KEVIN WISE TOWN PLANNING

Application By WP Commercials Ltd. For A 'Non-Material Amendment' Of Planning Permission 22/500007/FULL - 'Change Of Use Of Former Bus Depot (Sui Generis) To Vehicle Servicing And Repair Business (Class B2) And Construction Of Additional Workshop Unit' At Sheerness Bus Station , Bridge Road, Sheerness, ME121RH.

In addition to this supporting letter, the application submission includes the necessary completed application forms, a revised elevations plan KWTP.04 Rev A and the requisite application fee of £293-00.

Proposed Elevations

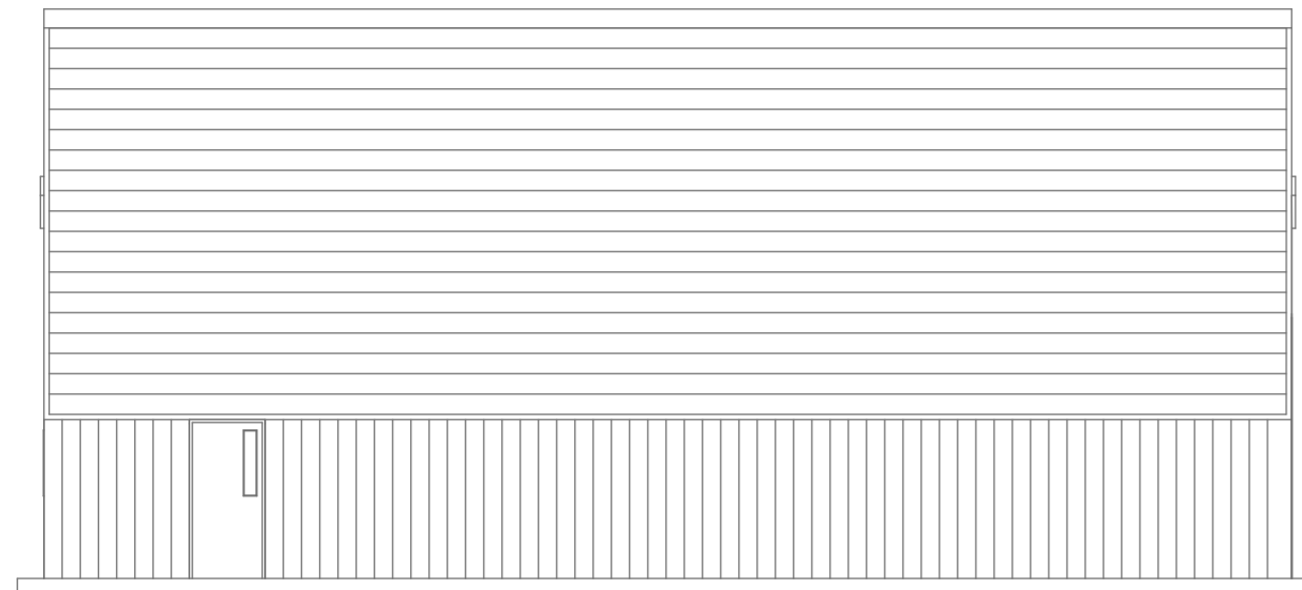
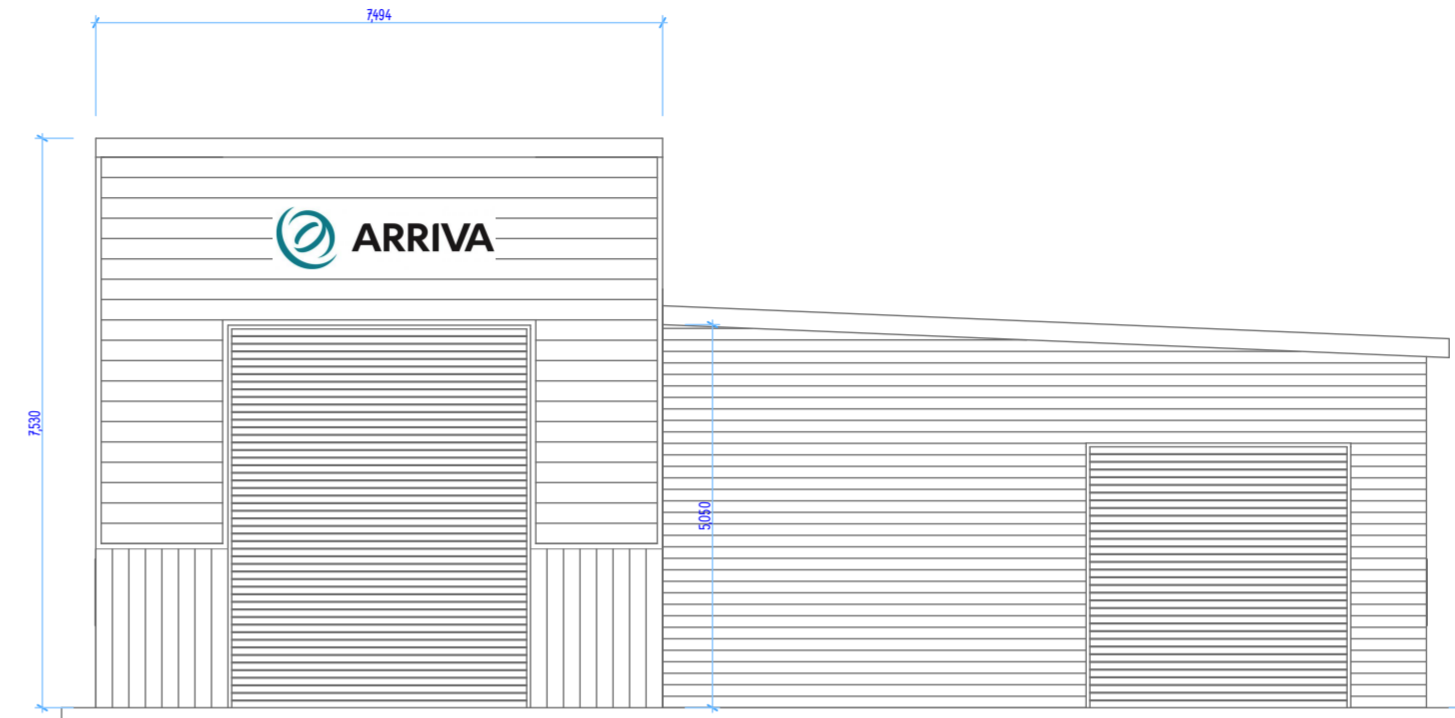
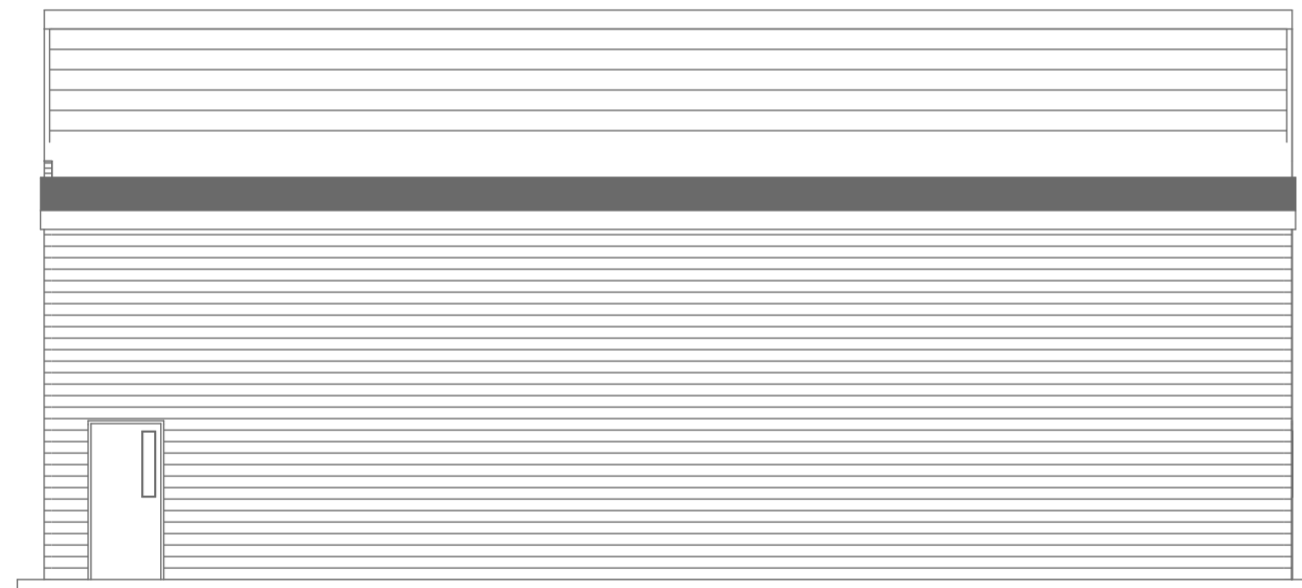
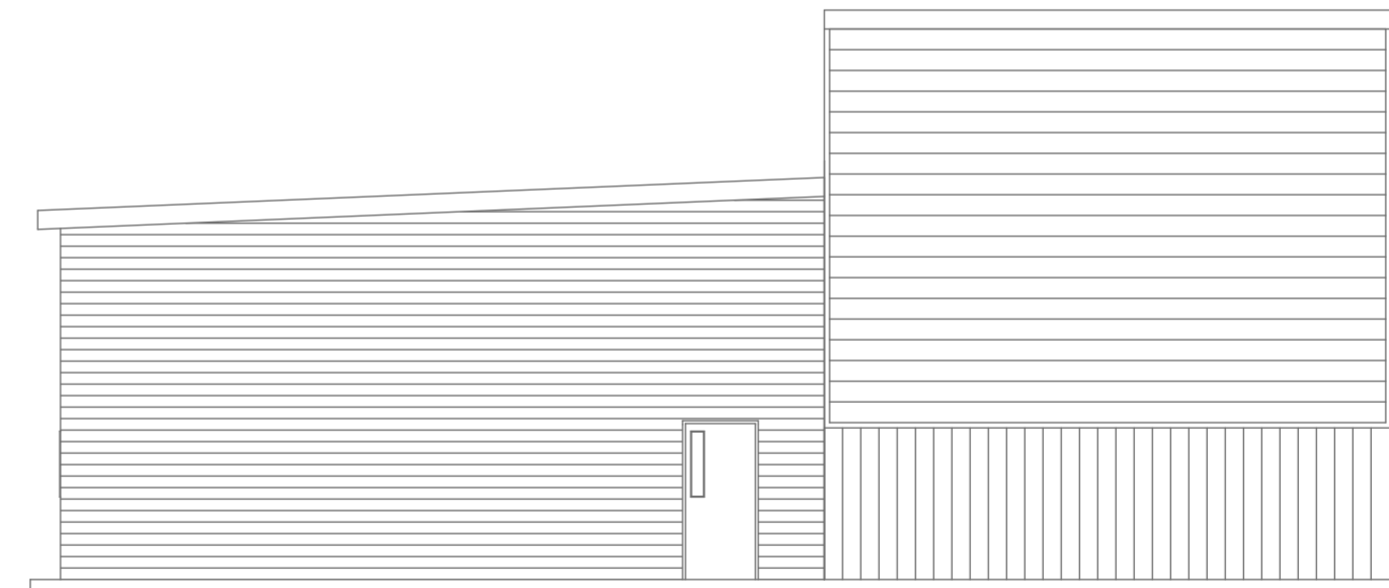
On behalf of my client, WP Commercials Ltd., please find enclosed an application seeking a 'non material amendment' of planning permission 22/500007/FULL. The amendment sought is a change in the roof of the building with a shallow, pent 'lean-to' style roof proposed in place of the approved flat roof design. The proposed alternative roof design is being proposed because it would be an improvement both in terms of its construction and also its aesthetics. The amended roof design would be both lower in overall height and also less bulky than the permitted flat roof design.
